CITY OF ALBUQUERQUE

**Re: PRESNow 24/7 Urgent and Emergency Care- 4515 Coors Blvd NW
Erosion Sediment Control Plan
Engineer's Stamp Date 2-11-19 (F11E019)**

Based upon the information provided in your submittal received 2-13-19, the above referenced plan is not approved to be included in the SWPPP or for NOI document review until the following comments are addressed:

EROSION SEDIMENT CONTROL PLAN

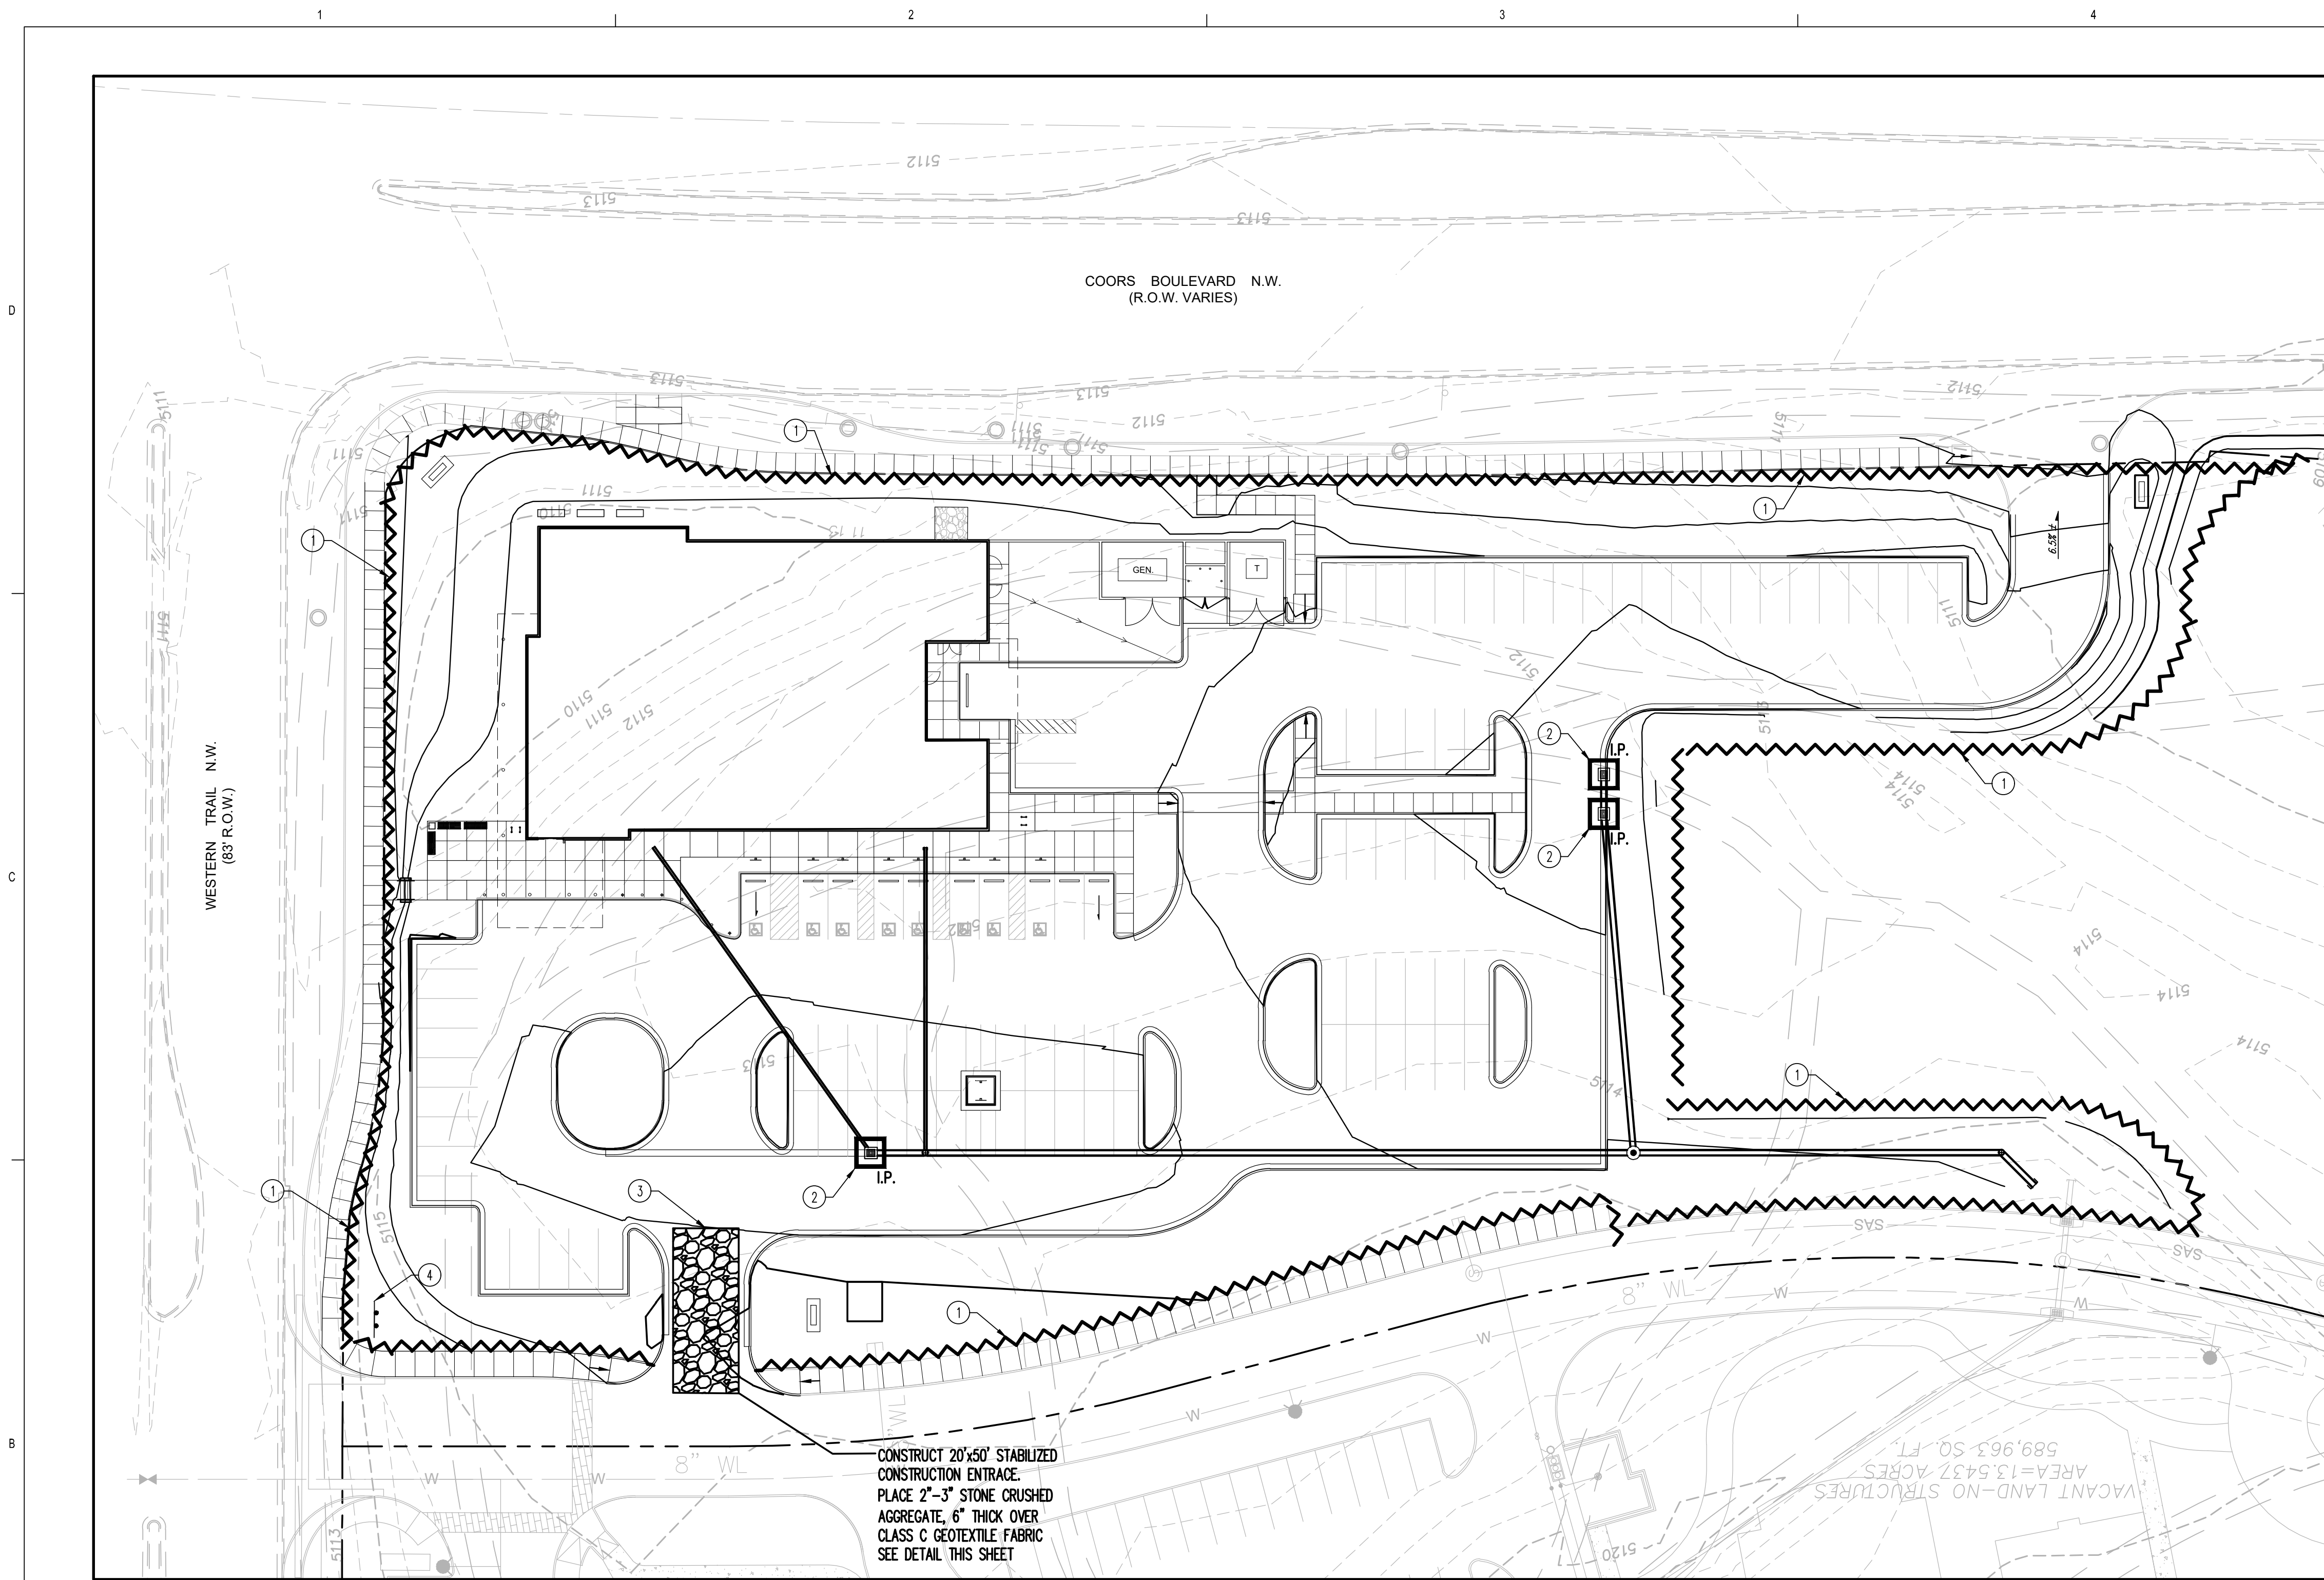
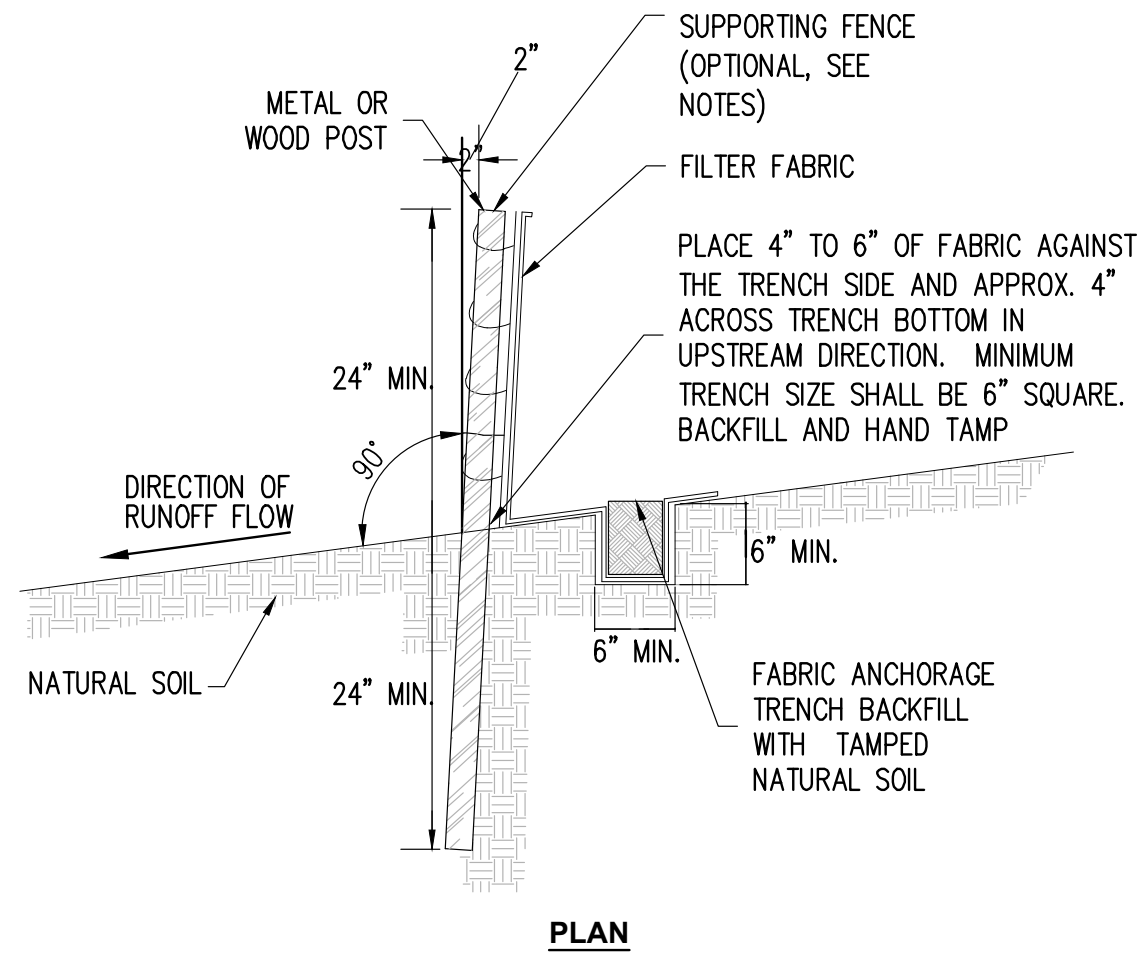
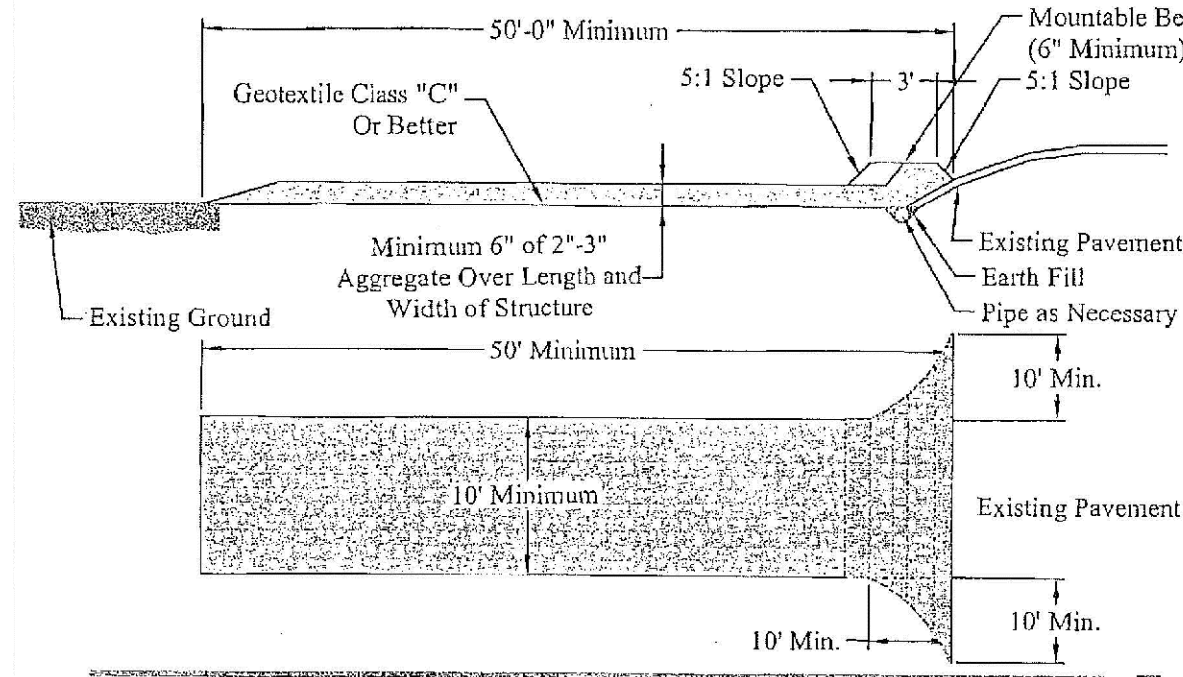
1. Provide proposed grades. The easiest way to do this may be to show proposed BMPs on the grading plan that is submitted to Hydrology.
2. Provide a Vicinity Map.

3. Is the pipe on the west side of the building for roof drains? Open-ended pipes are treated the same as inlets and require inlet protection as they are constructed earlier in the project than the building.

4. The access drive and storm drain system on the west side of the site are shown as existing, but are not constructed. Will this project be constructing the access drive and storm drain system? If so, provide BMPs for the disturbed area.

5. If the site work precedes the access drive, then I would recommend the Stabilized Construction Entrance be located on Western Trail rather than on Coors Blvd.

6. General Note A places all NPDES permitting and reporting responsibility on the contractor. The contractor cannot certify the NOI or file the NOT for the Owner, the owner must do this.

7. Please revise EROSION CONTROL NOTE A. BMPS are to be installed prior to earth disturbance rather than concurrent.
8. The EROSION CONTROL NOTES allow the use of straw wattle for a sediment BMP. If proposed grades show slopes taller than 3 or 4 feet, then silt fence only should be specified as straw wattles are not tall enough.

9. The approved Site Plan shows a larger parking lot. If the parking lot is constructed per the approved Site Plan rather than the extent shown on this plan, the sediment BMP is to be located at the south end of the disturbed area.
